Planning Act 2008 (as amended) – Section 51

Application by Gate Burton Energy Park Ltd for an Order Granting Development Consent for the Gate Burton Energy Park.

Advice following issue of decision to accept the application for examination

Drawn	Checked	Approved	Date
CG	SM	BW	JAN 2023
GH Project Number 144625.001		Scale at A1 1:2,500	
Drawing Number GH-144625001-LP-2			Revision 1.0

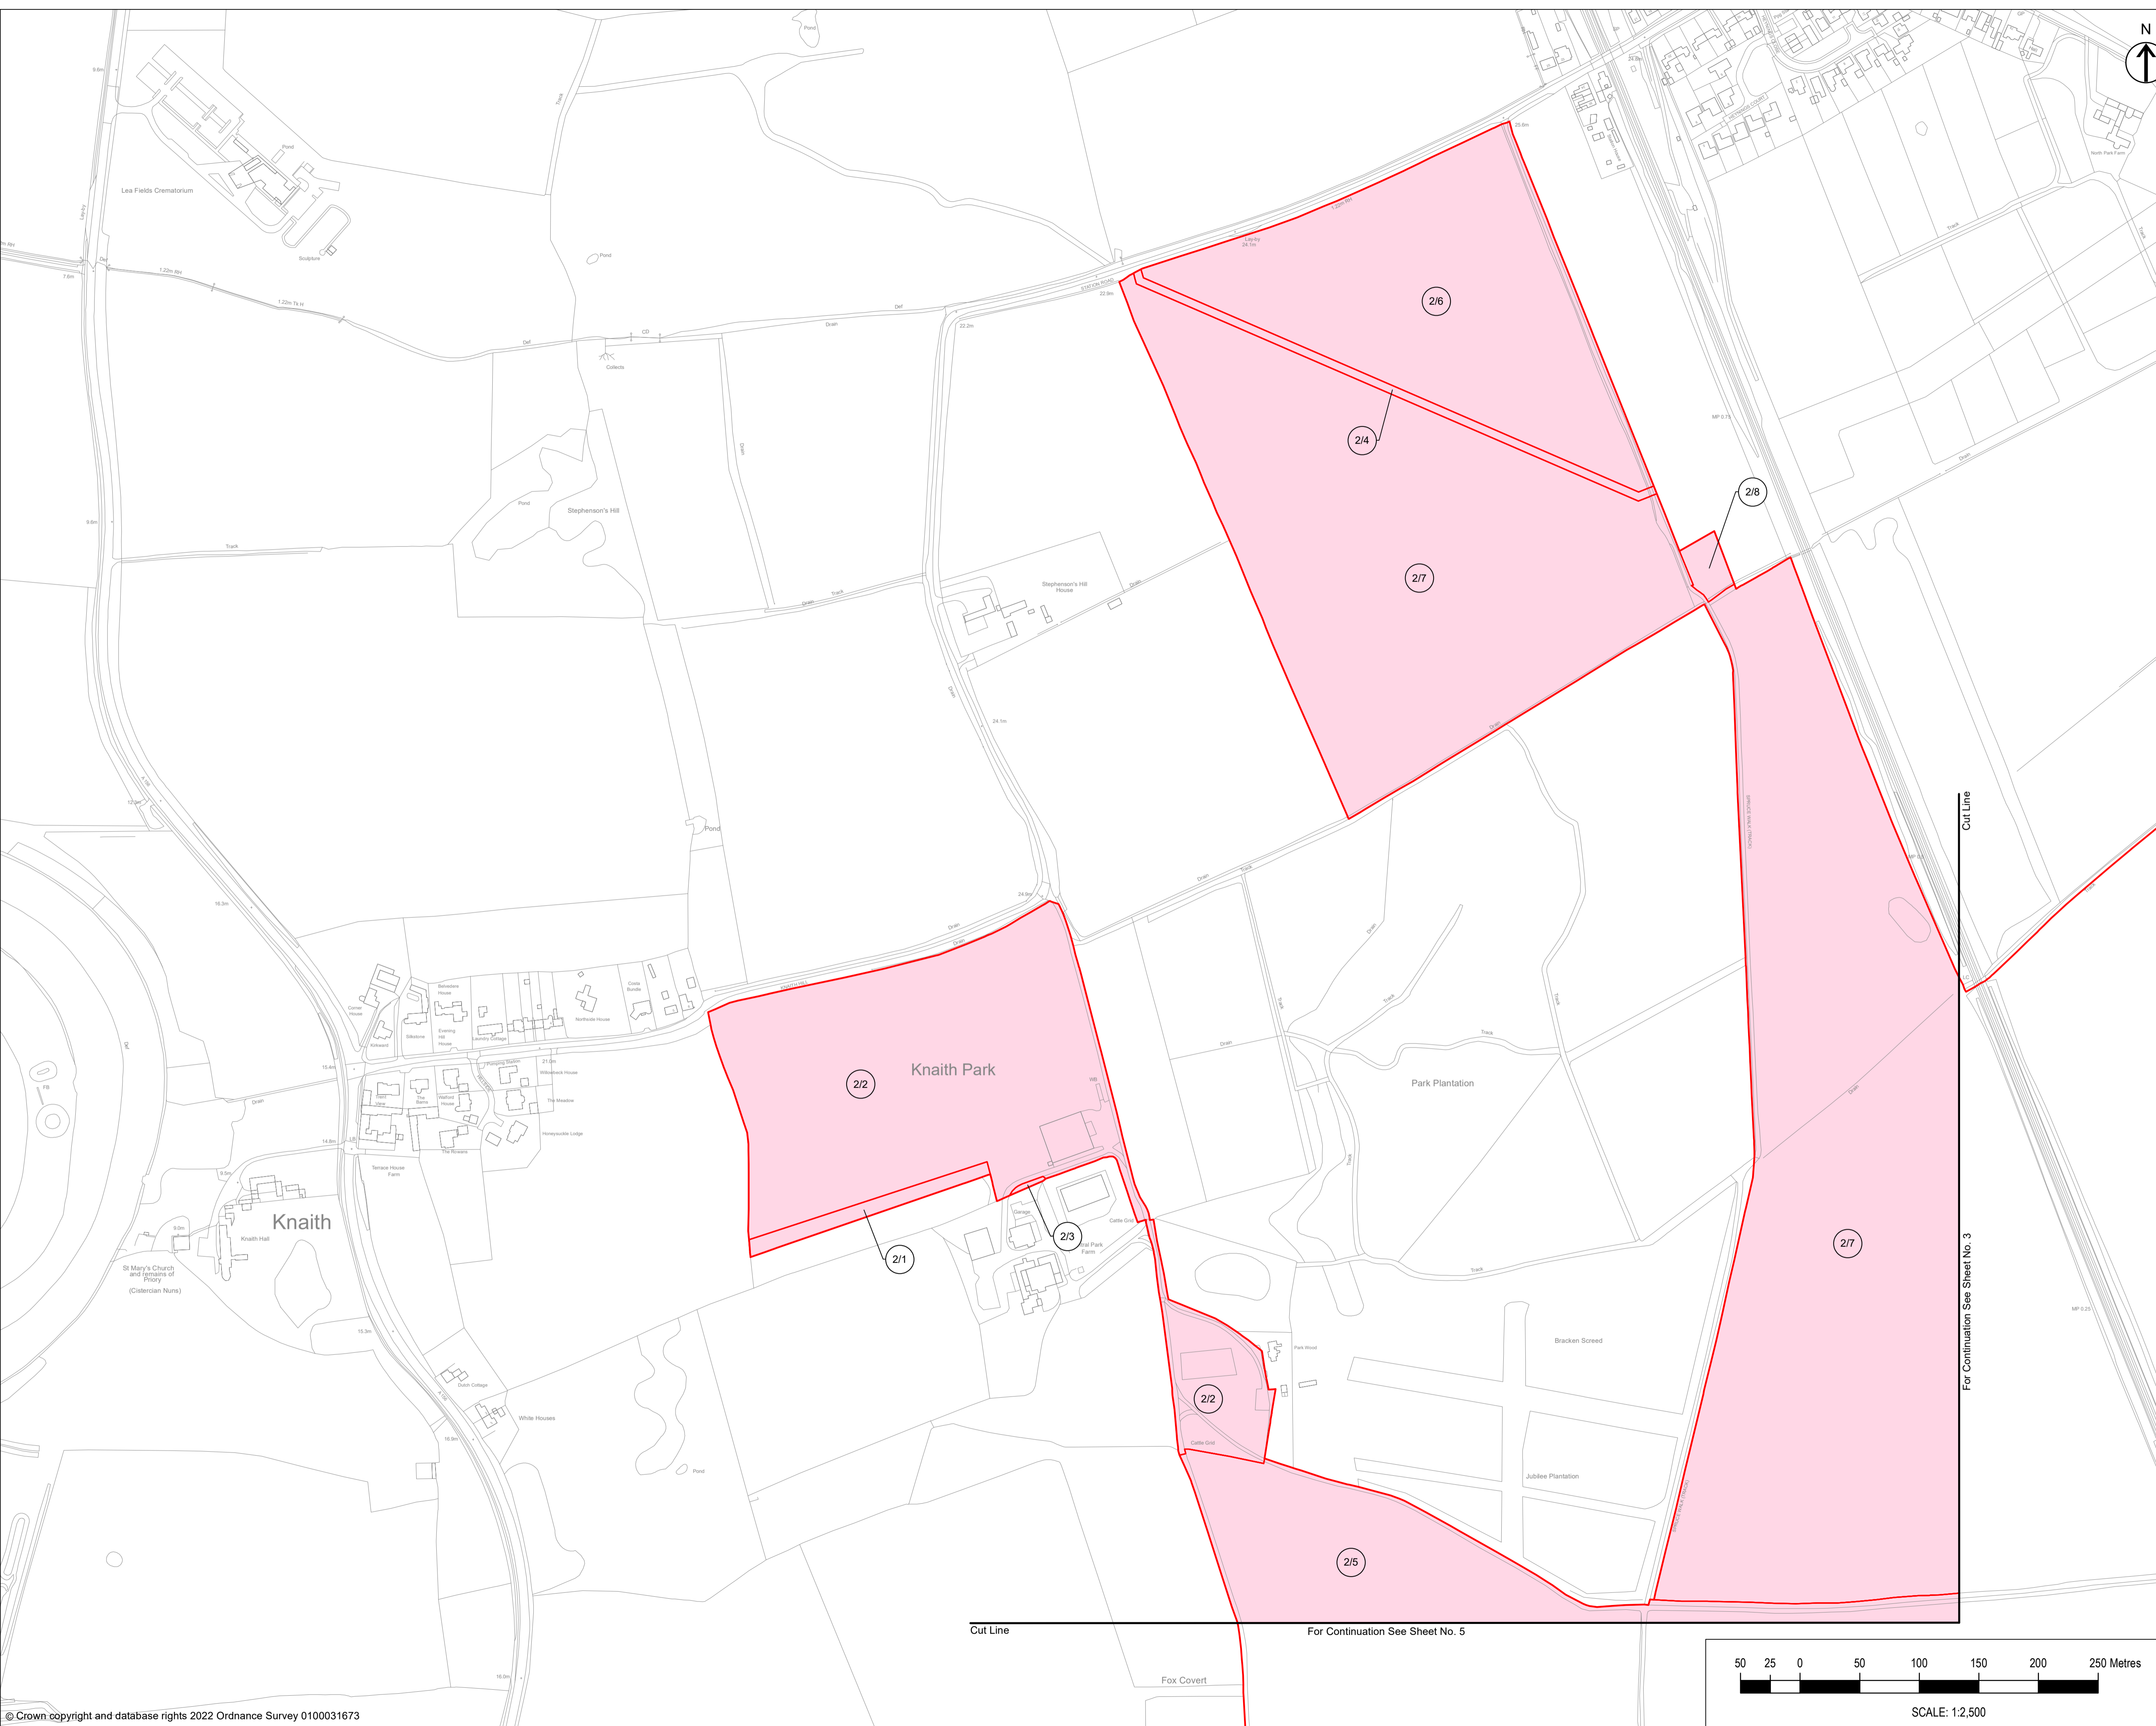
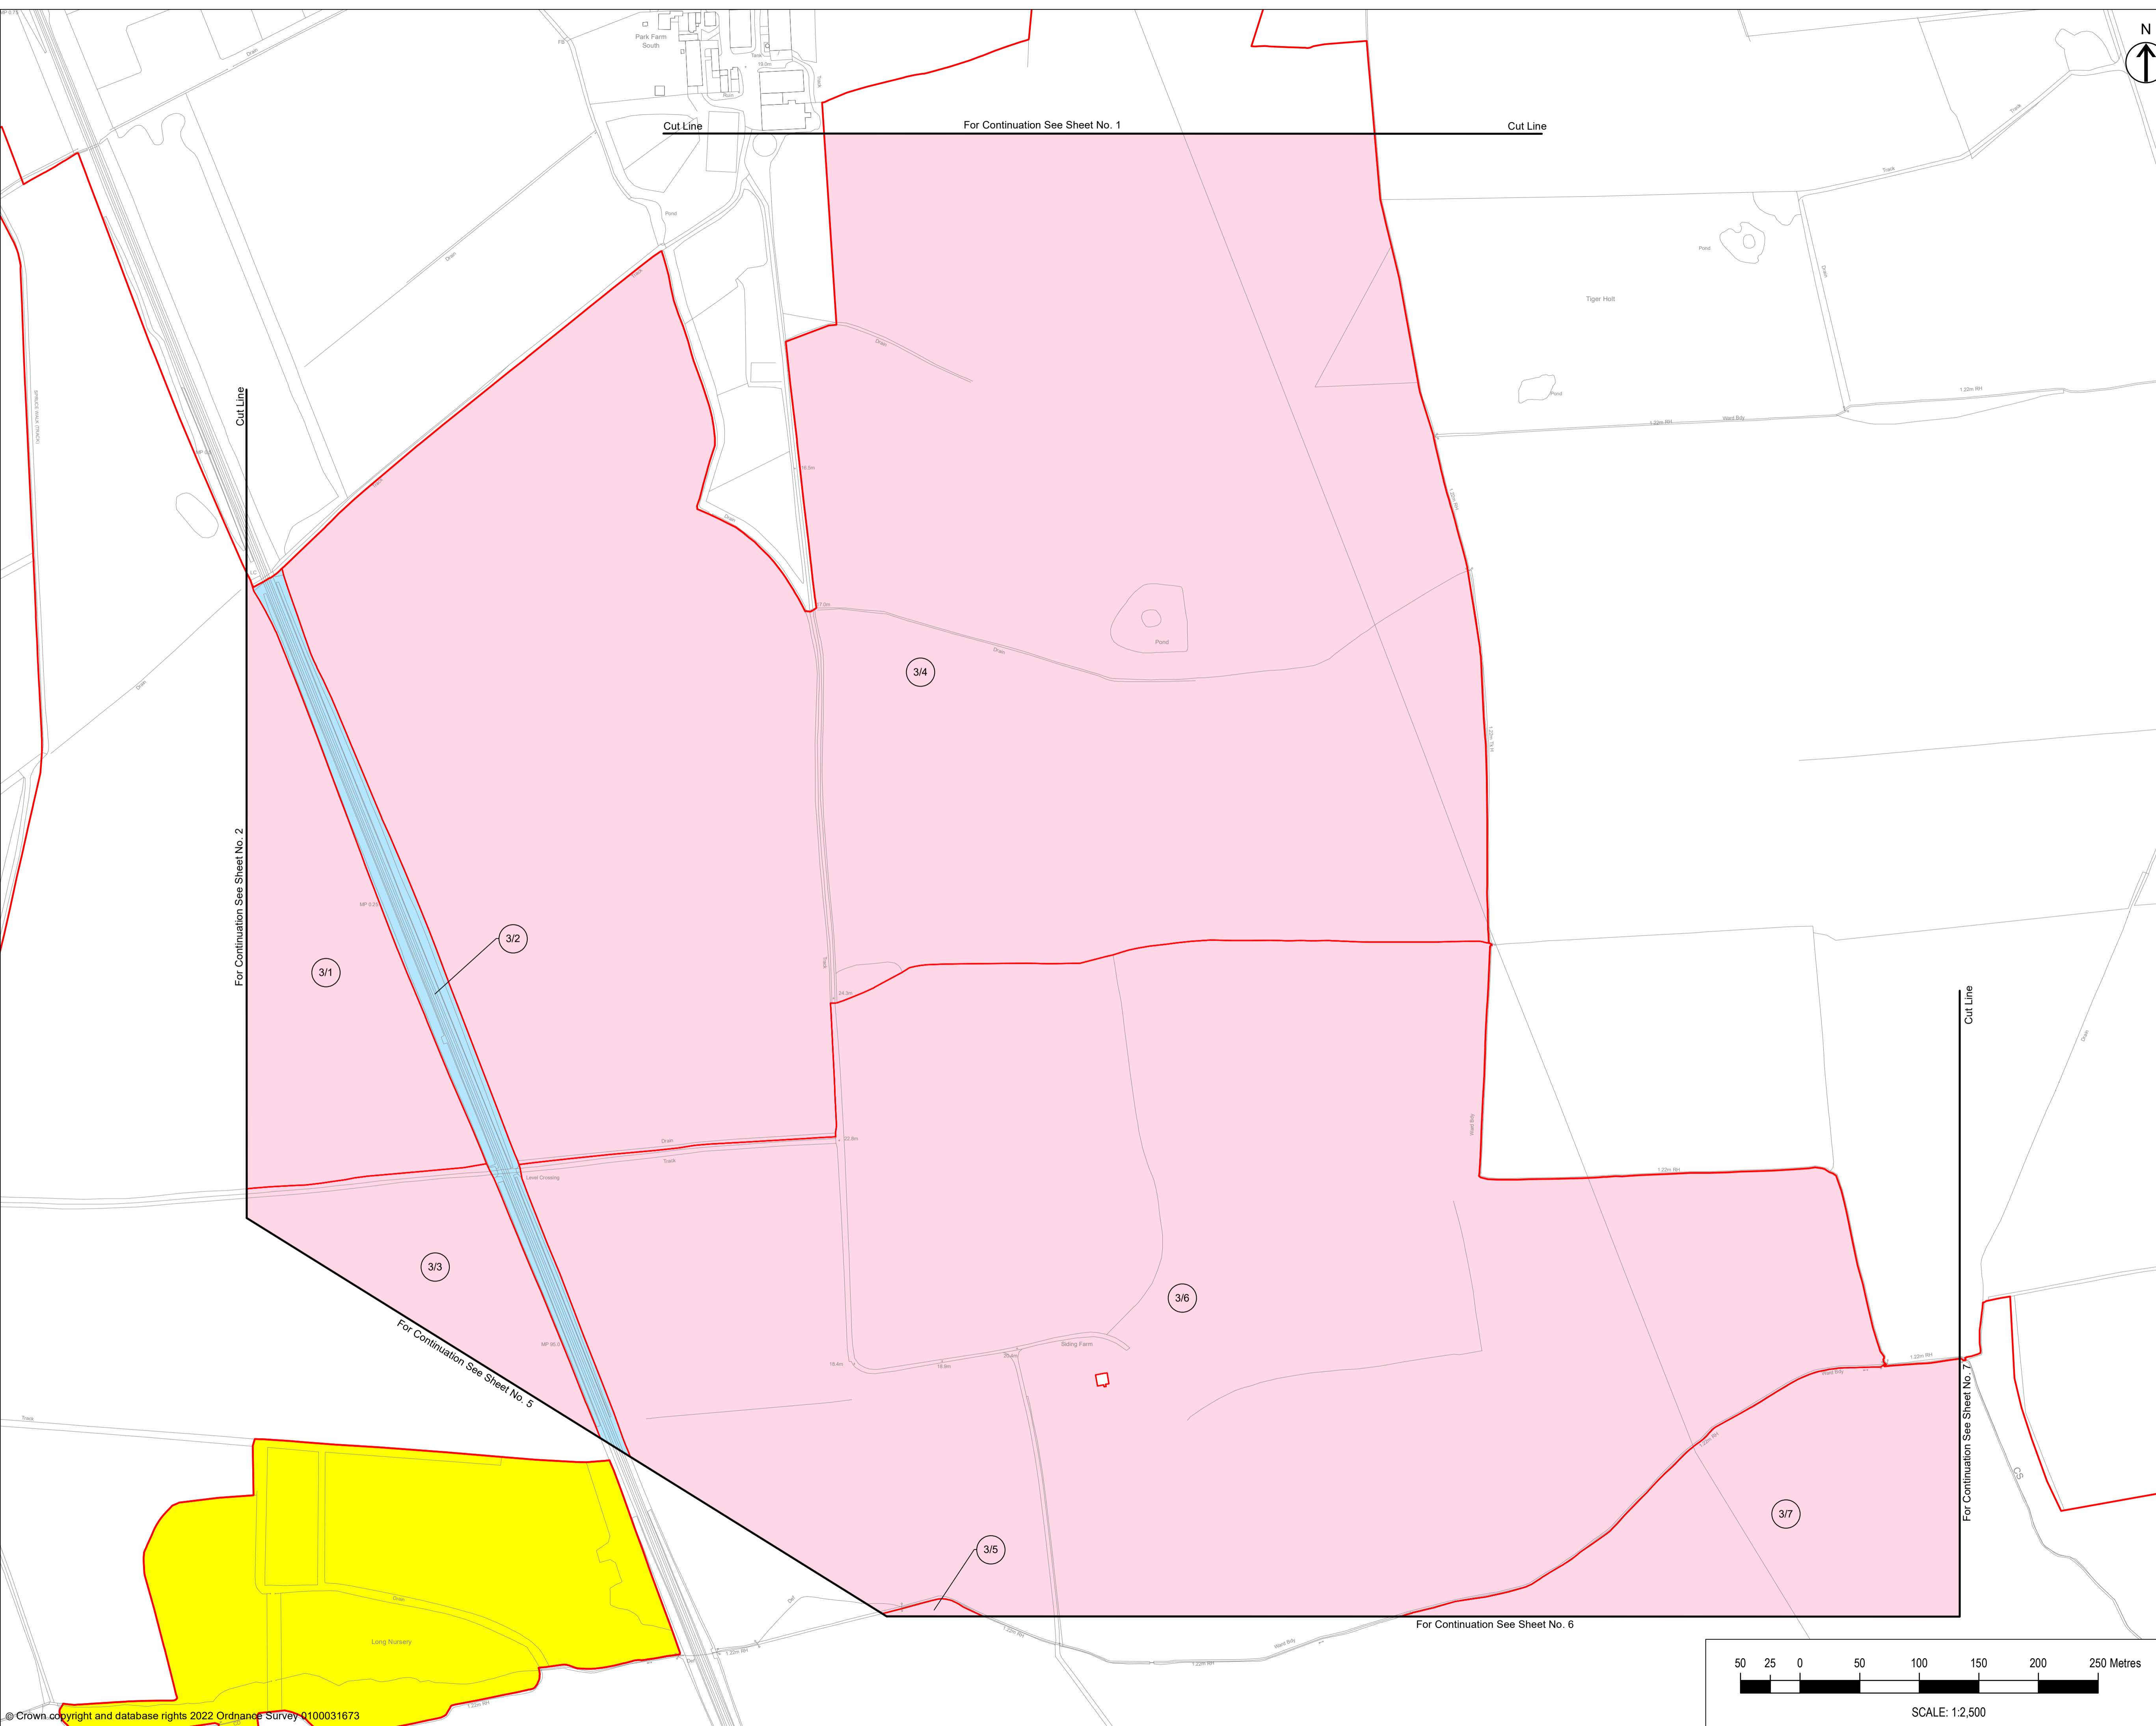
The Applicant is advised to undertake a cross-check of the Land Plans with the descriptions used in the BoR, to ensure clear and consistent read across both documents. Where geographical identifiers, such as road names and settlements, have been used in the BoR to help locate plot(s) on the Land Plan(s), these identifiers should be included on the relevant plan.

A consistency check of the colouring of the plots should be conducted, as well as labelling of inserts on plans, the Applicant should review all Legends on the Land Plans to ensure no typographical errors, as per the errors highlighted in Box 30 of the acceptance checklist.
